Application No: FG/54/22/PL
Site Address: Land rear of 1 Sea Drive Ferring BN12 5HD
Description of works: 1 No new dwelling. This application is in CIL Zone 4 and is CIL Liable as new dwelling.

Thank you for your internet representation made on 29th April 2022 which has been recorded as an objection with the comments as follows:

Project: New build dwelling		
for SB24 Ltd		
at Land to Rear of 1 Sea Drive Ferring Worthing BN12 5HD		
Dwg Ref: 2114 [PL] 02		Rev: A
Date: Jan 2022

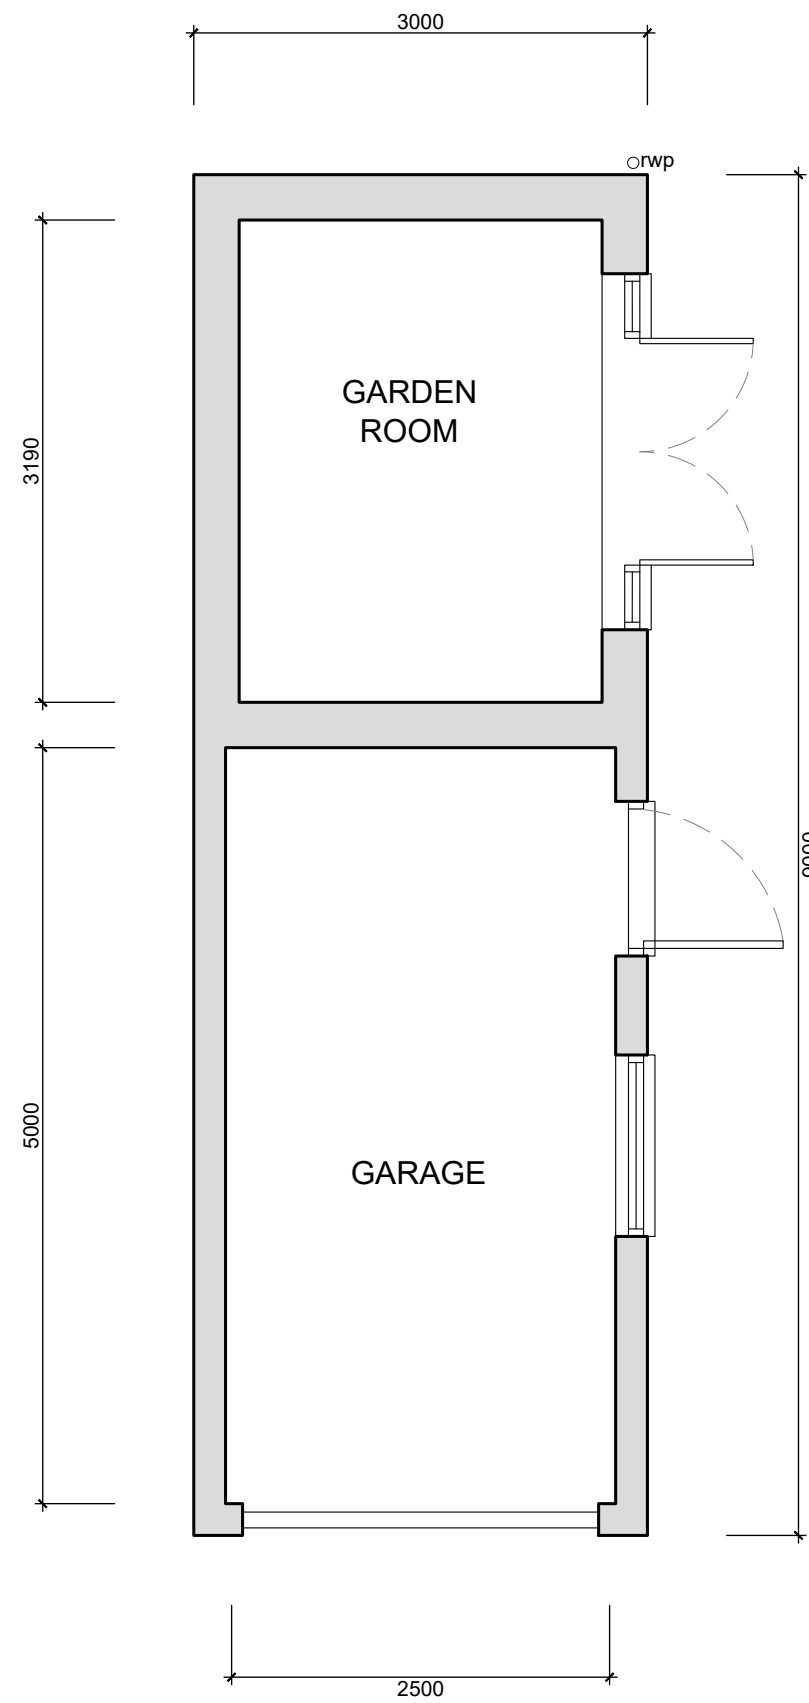
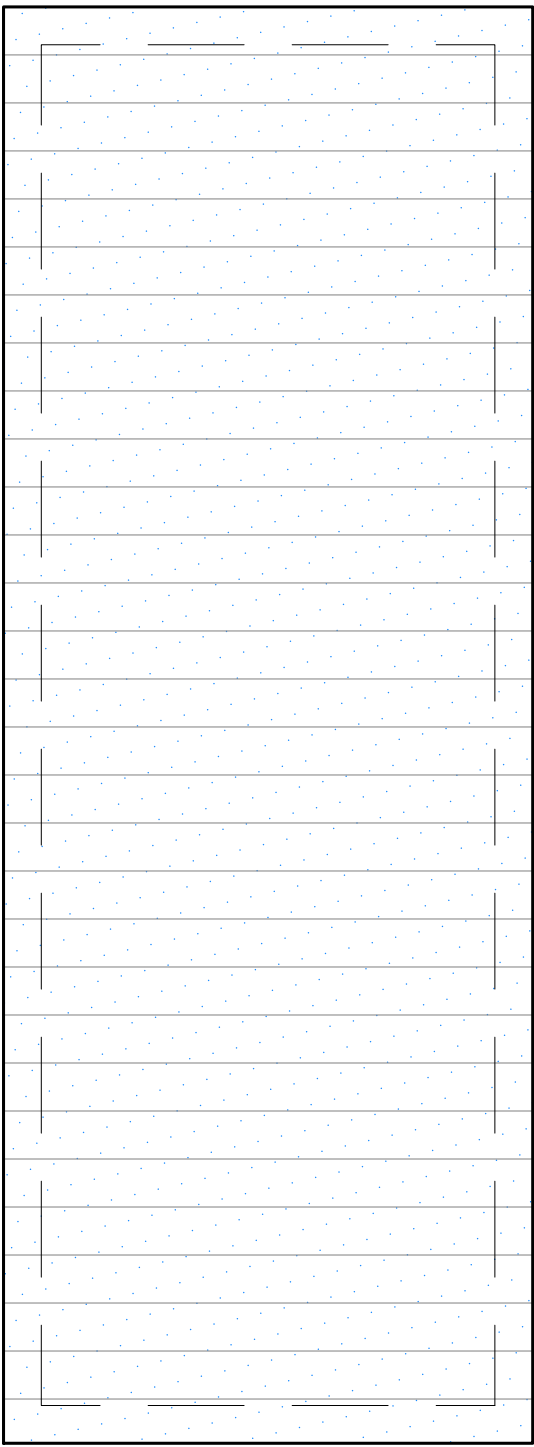
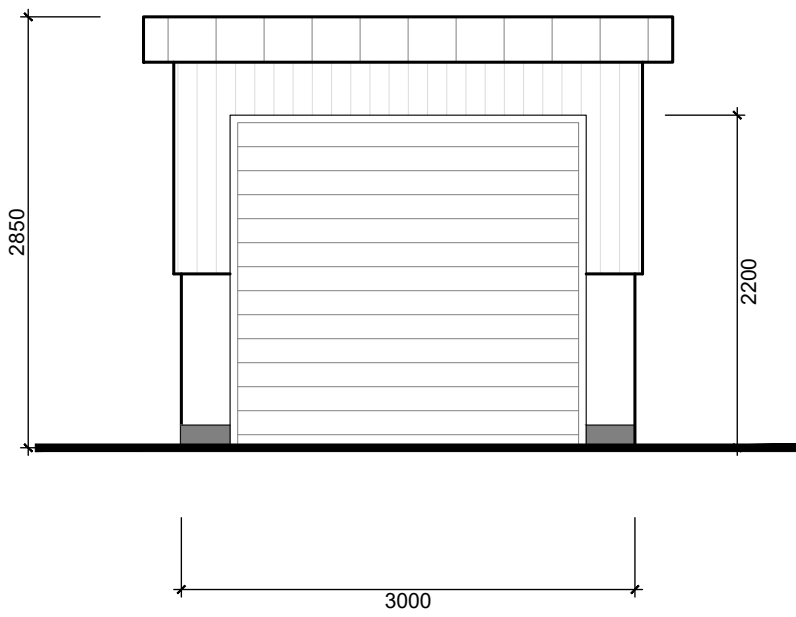
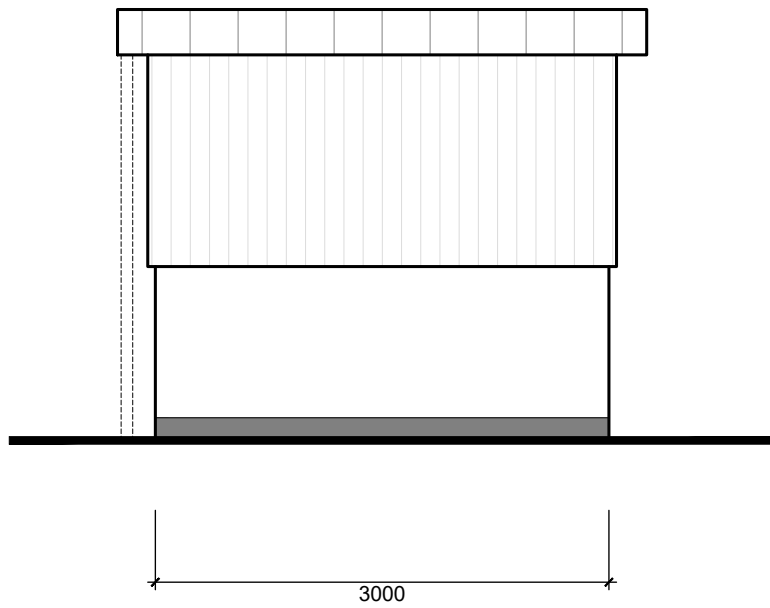
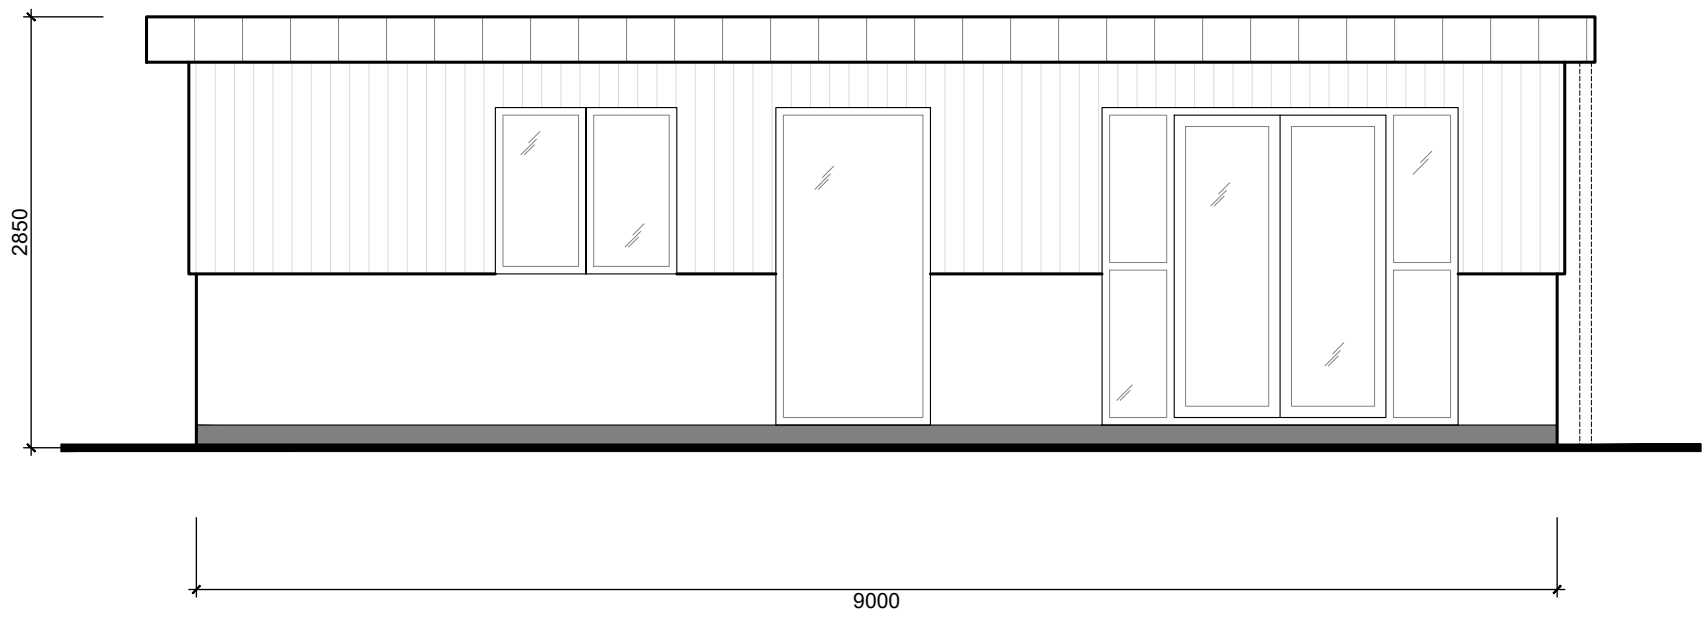
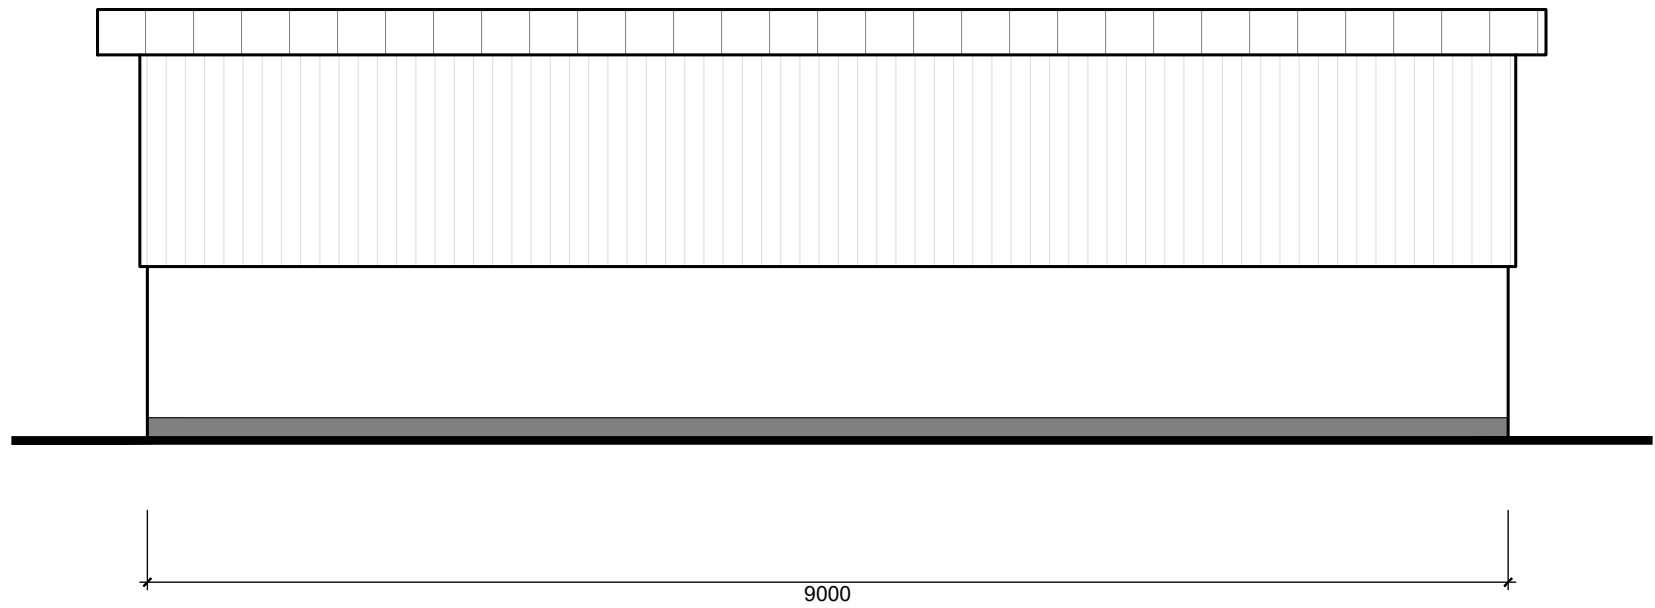
The overdevelopment of the site and restricted plot size leads to the likely necessity for vehicles to enter or leave the site in reverse gear. The garage shown on the plans does not meet the required single bay dimensions and cannot be considered as a viable parking addition for a modern vehicle. The WSCC Highways report erroneously specifies a new access from Sea Drive but the access proposed is from Sea Lane. Its positioning in Sea Lane is the same as was proposed on an earlier application for flats on the site but withdrawn on safety grounds with a redesign to access from Sea Drive. That option is not available for the application site due to the current redevelopment of the main building (1 Sea Drive). Sea Lane is a busy, narrow road and the site is close to a sharp bend on a junction. There have been other safety issues in Sea Lane, albeit further to the north of this site, where WSCC have invested in a build out to create a single file chicane following a serious accident. To permit an access driveway at this end of Sea Lane so close to the

Proposed Site Plan  
Scale 1:100 @ A1

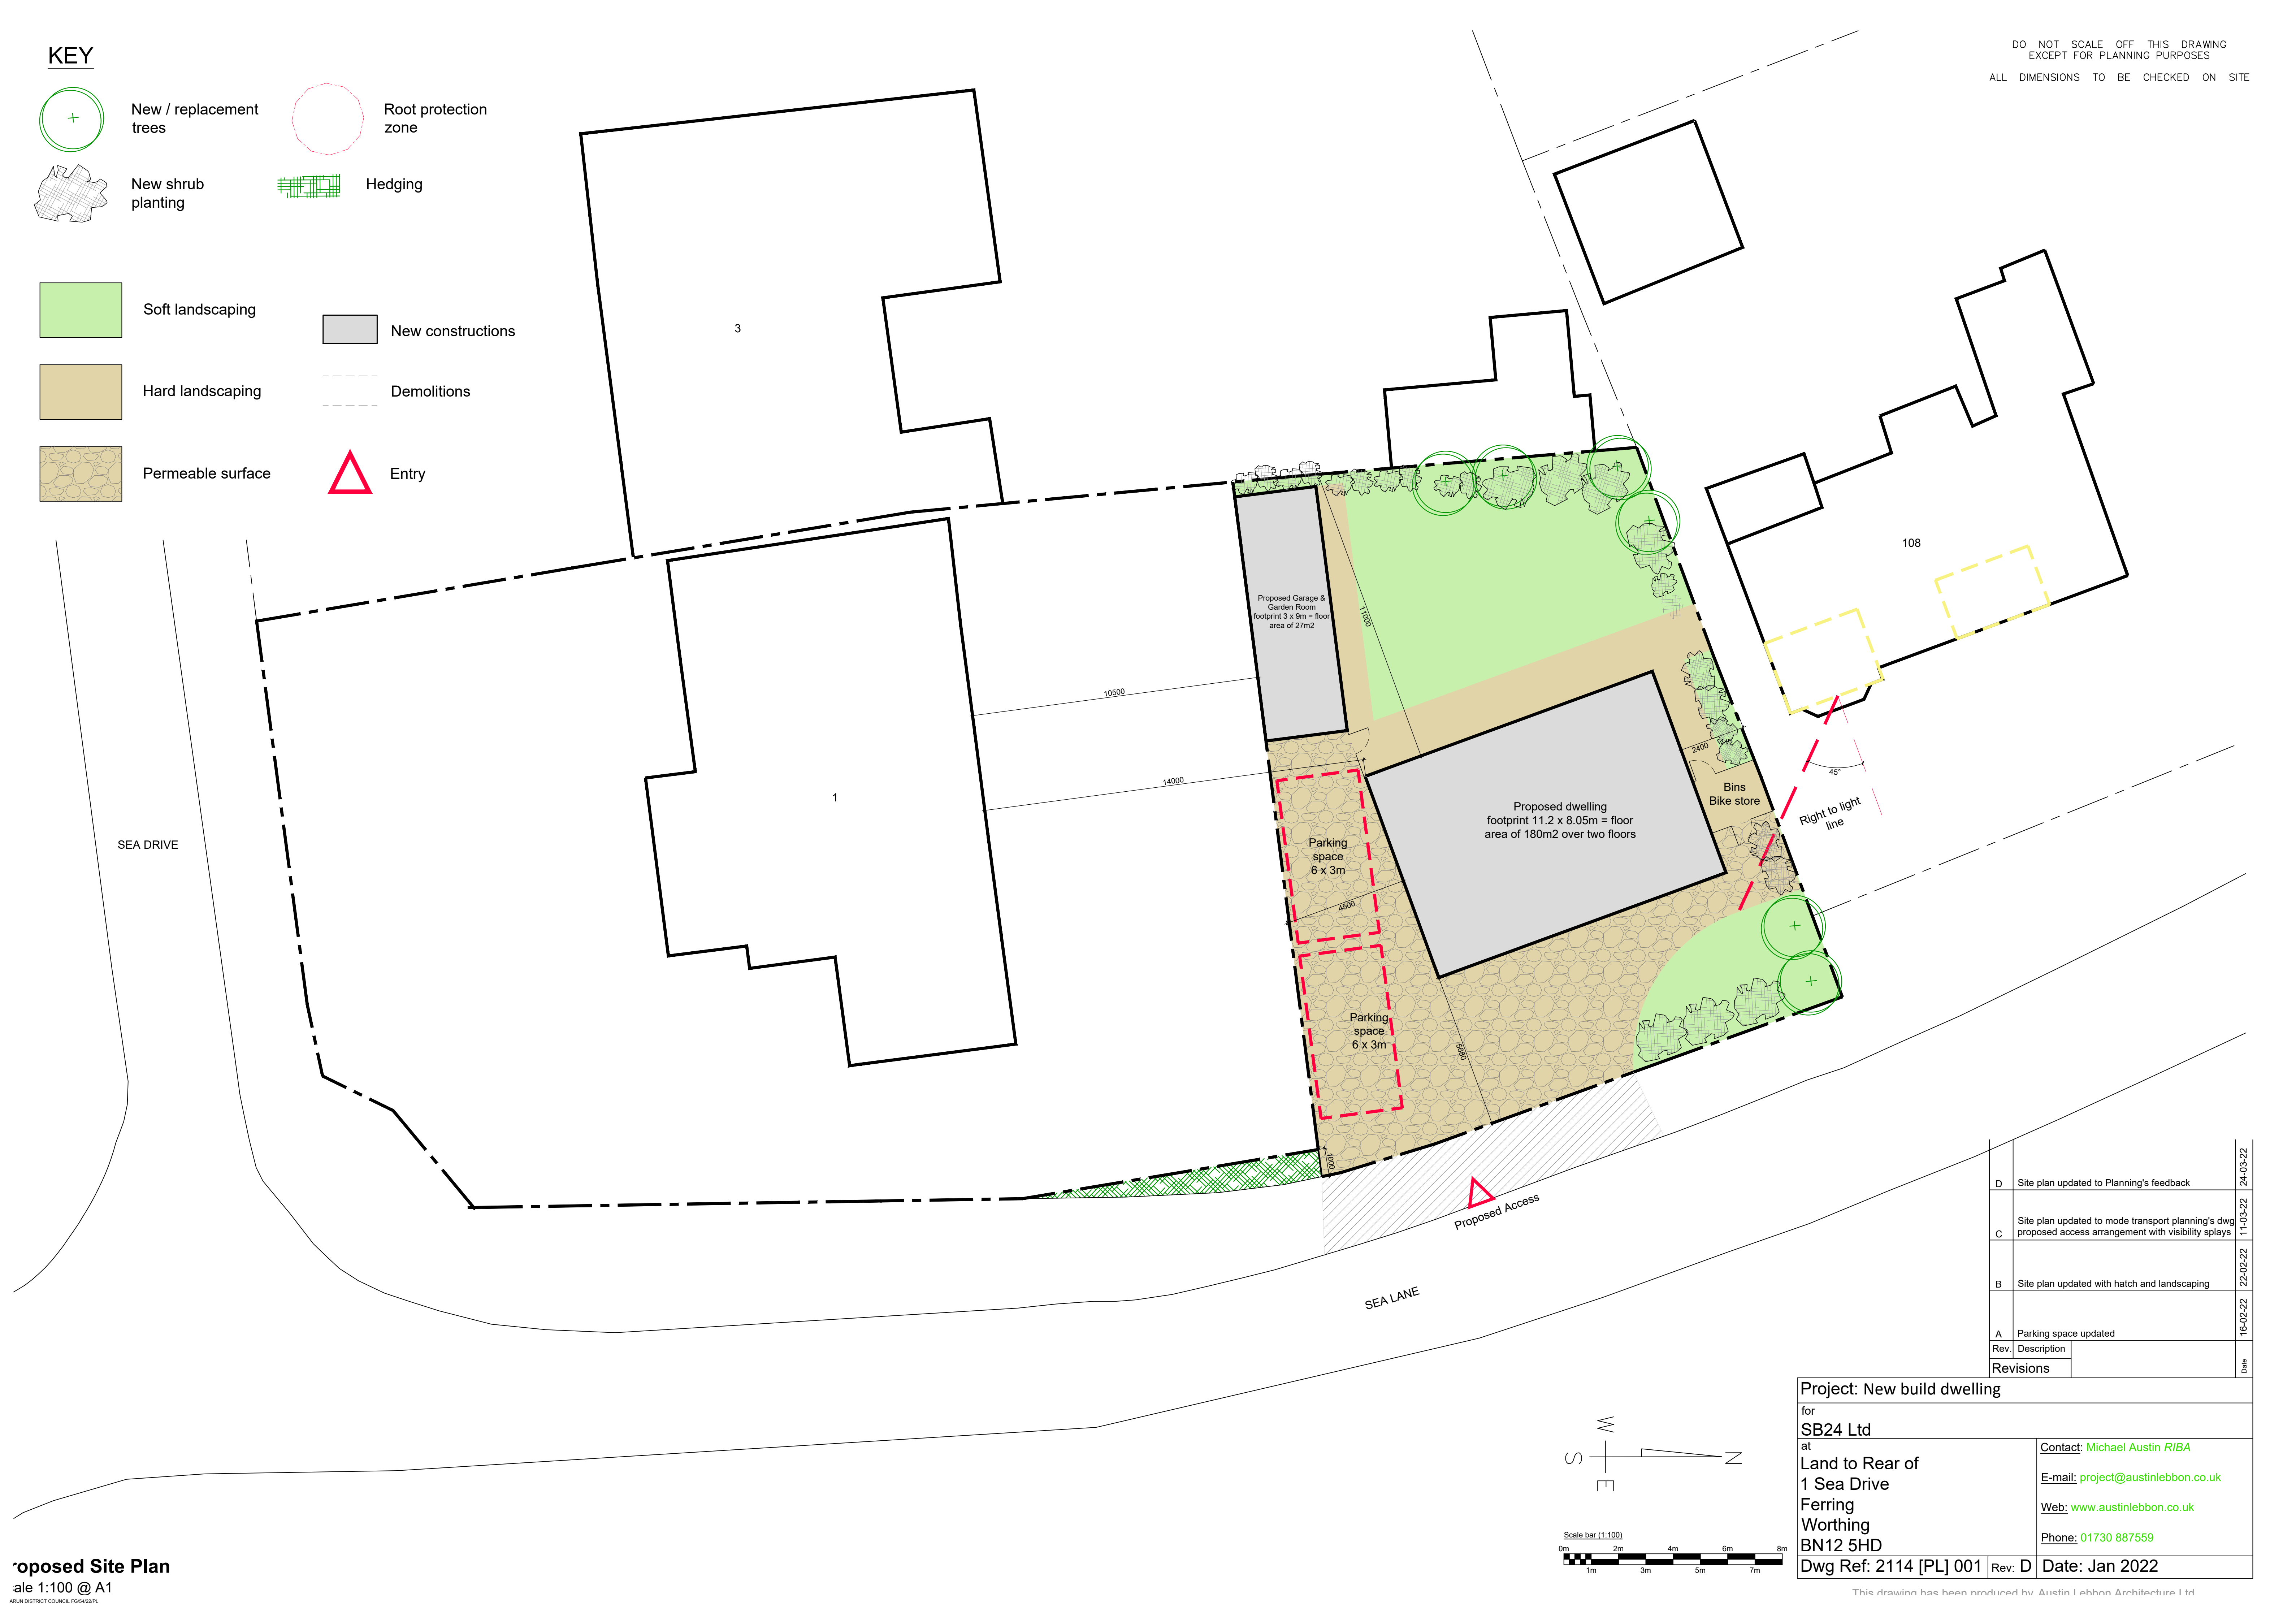
bend/junction would raise a new safety risk where the risk is not currently present.

- is an overdevelopment of the site,
- diminishes the plot size of 1 Sea Drive on which the redevelopment of that dwelling was substantially based,
- creates an unsafe vehicular access driveway with insufficient turning space
- is detrimental to the street scene through over density for the location,
- is positioned too far forward on the site creating a harmful visual impact
- due to its positioning it is detrimental to the visual outlook of the adjacent property in Sea Lane
- creates harmful overshadowing and overlooking of the adjacent property in Sea Lane.
